PLANNING & COMMUNITY DEVELOPMENT DEPARTMENT
Land Use Review Division

January 25, 2022

RE: Amara (Annexation, Mater Plan and Zoning) – Initial Review Comments
File: CPC A 21-00197 – CPC A 21-00207, CPC MP 21-00208, CPC ZC 21-00209

CITY FILE NO. CPC A 21-00207
610 N. Comstock Avenue, Suite 200
Orem, UT 84057
(801) 225-0790
(801) 225-0799 (FAX)

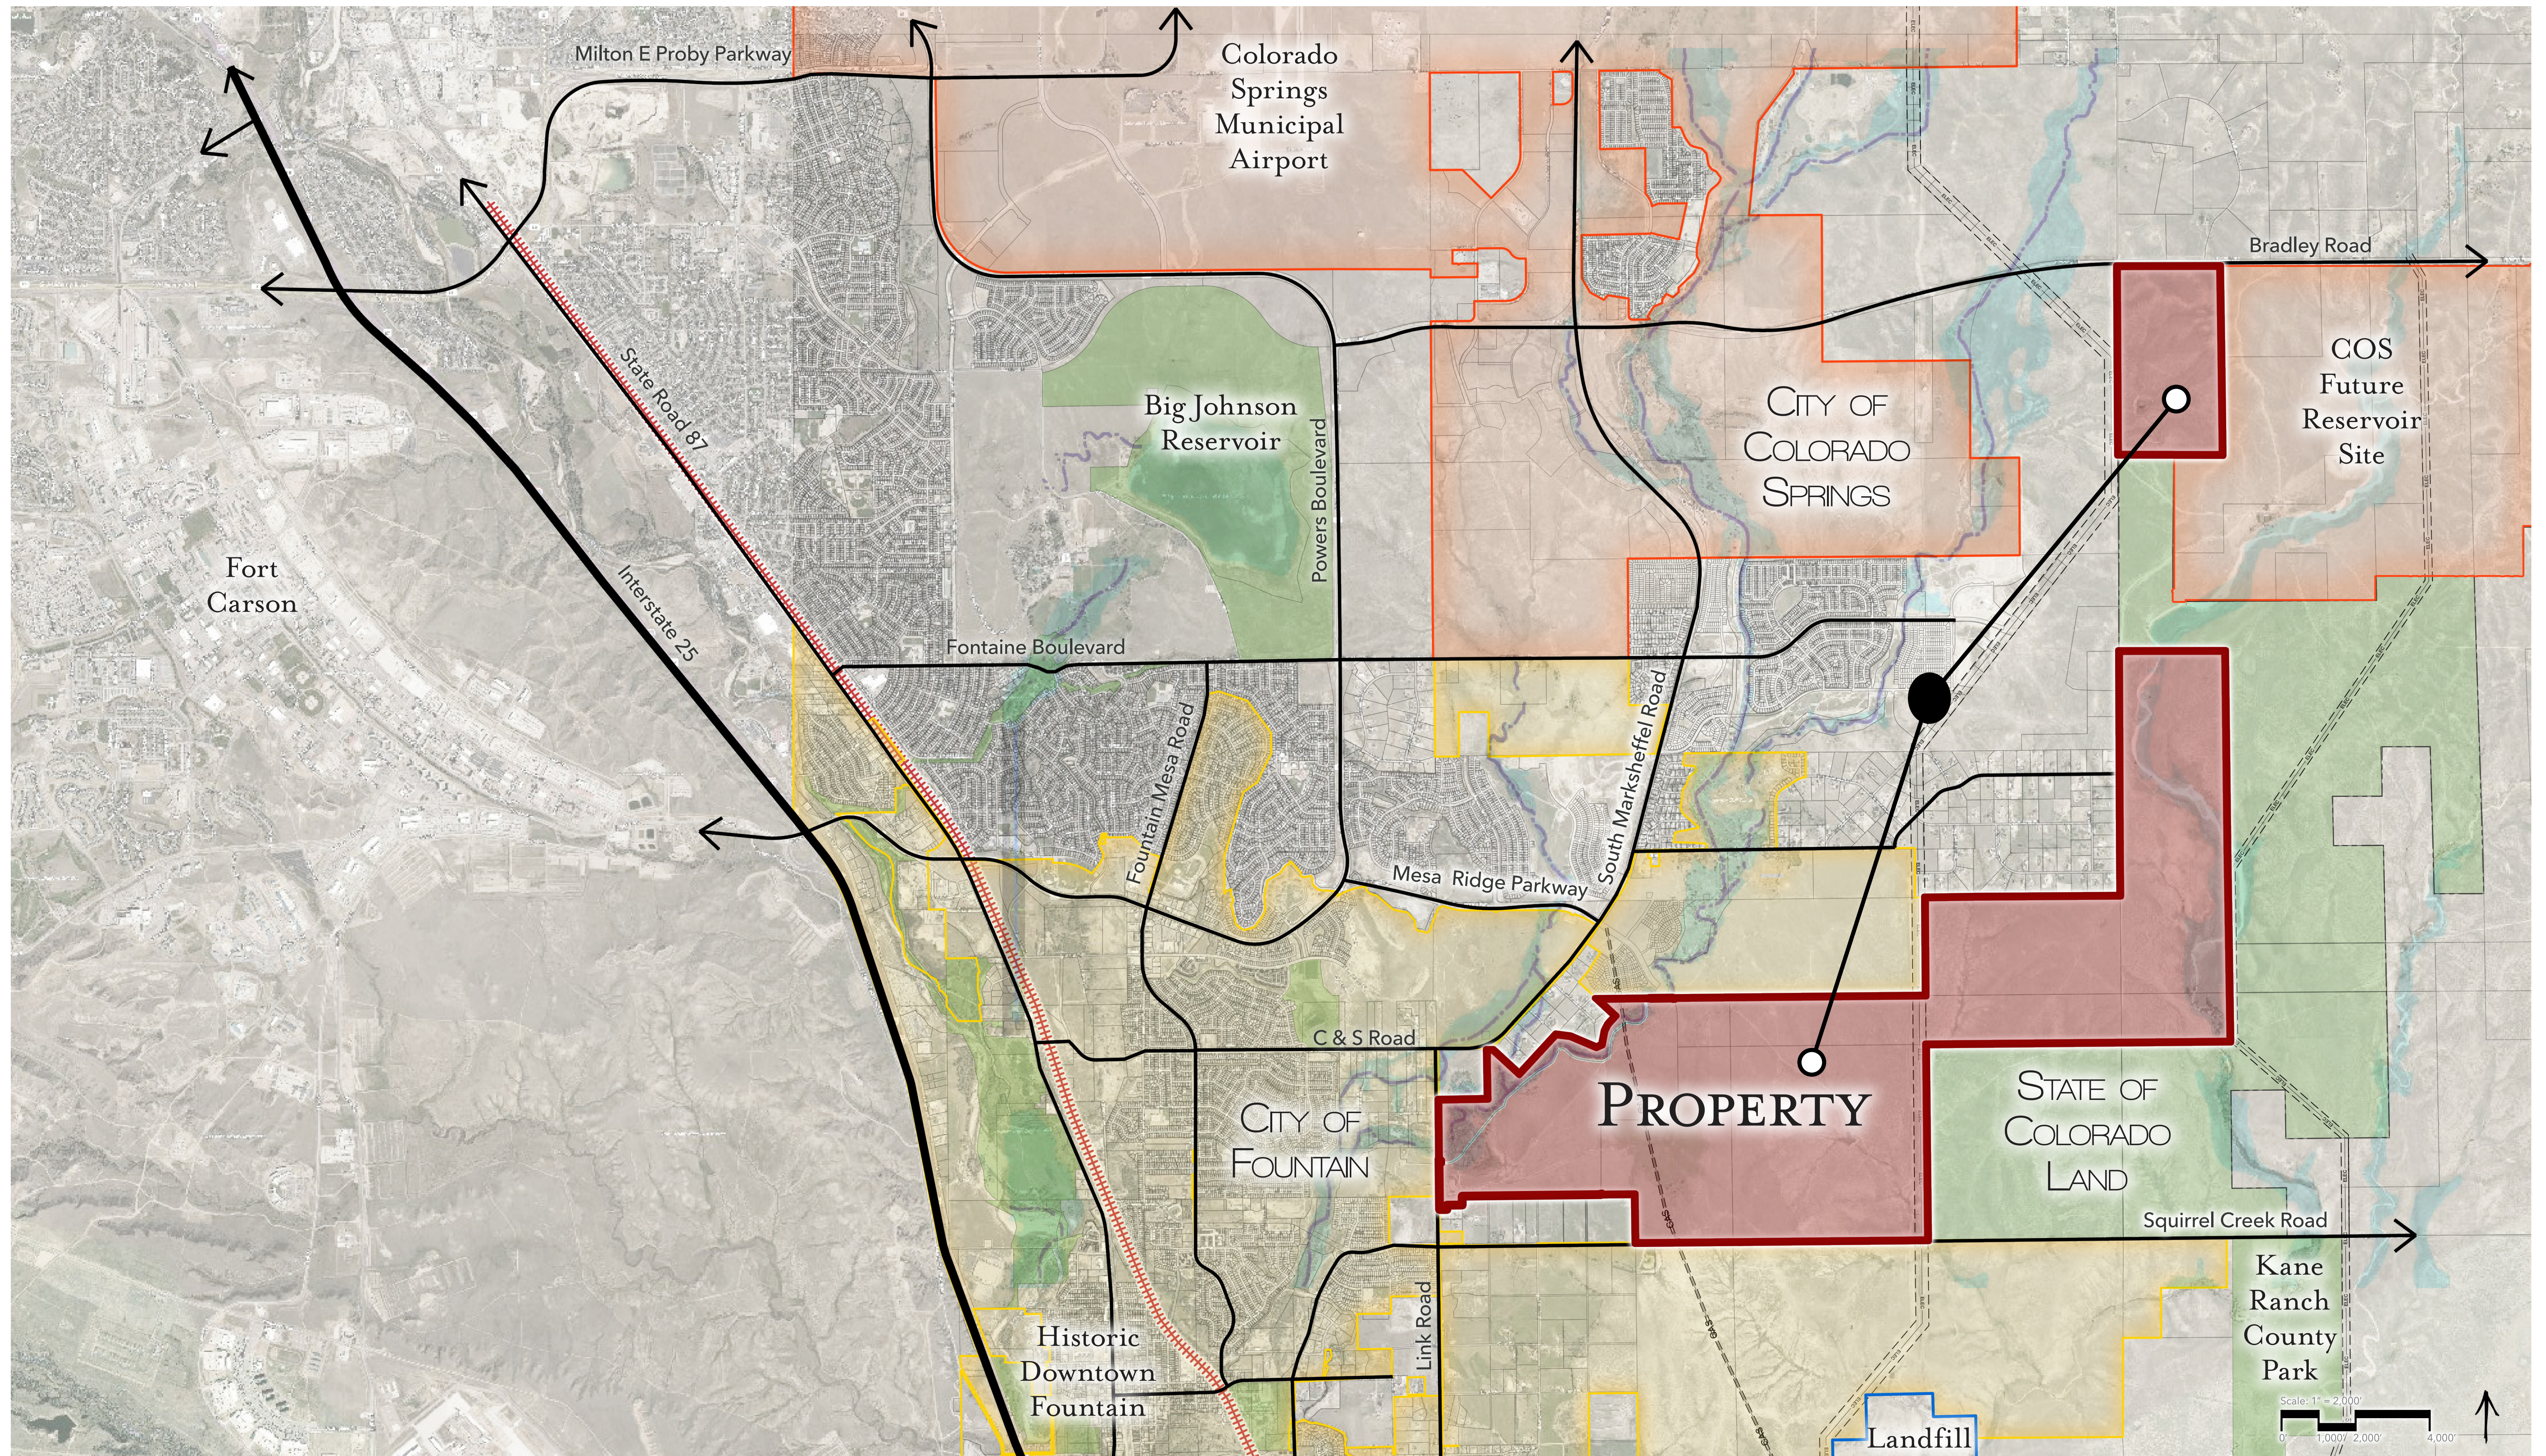
1. Please add the missing "be it known by these presents".
2. Please complete the City File No. CPC A 21-00207.
3. Please add the distance to the third course within the legal description (S 01-07-56 E 2629.96').

4. When adding the area with a calculator the total perimeter is 30800.63', please verify.
5. Please add some additional section labels for section 26 and 27.

6. Please label the lot numbers in Fountain Valley Land & Irrigation Co. Subdivision No. 1.
7. Please depict and label the Fountain Mutual Irrigation ditch as it cross the property and should tie into the canal as depicted on the adjacent plat to the south.

8. Please add the record information for Squirrel Creek Road.
9. Please check the line as depicted for the easterly line of the southeast quarter of section 33, as the monuments location lies easterly of the line as depicted.

10. Does Road Book A at Page 78 have any effect on any of these parcels being annexed?
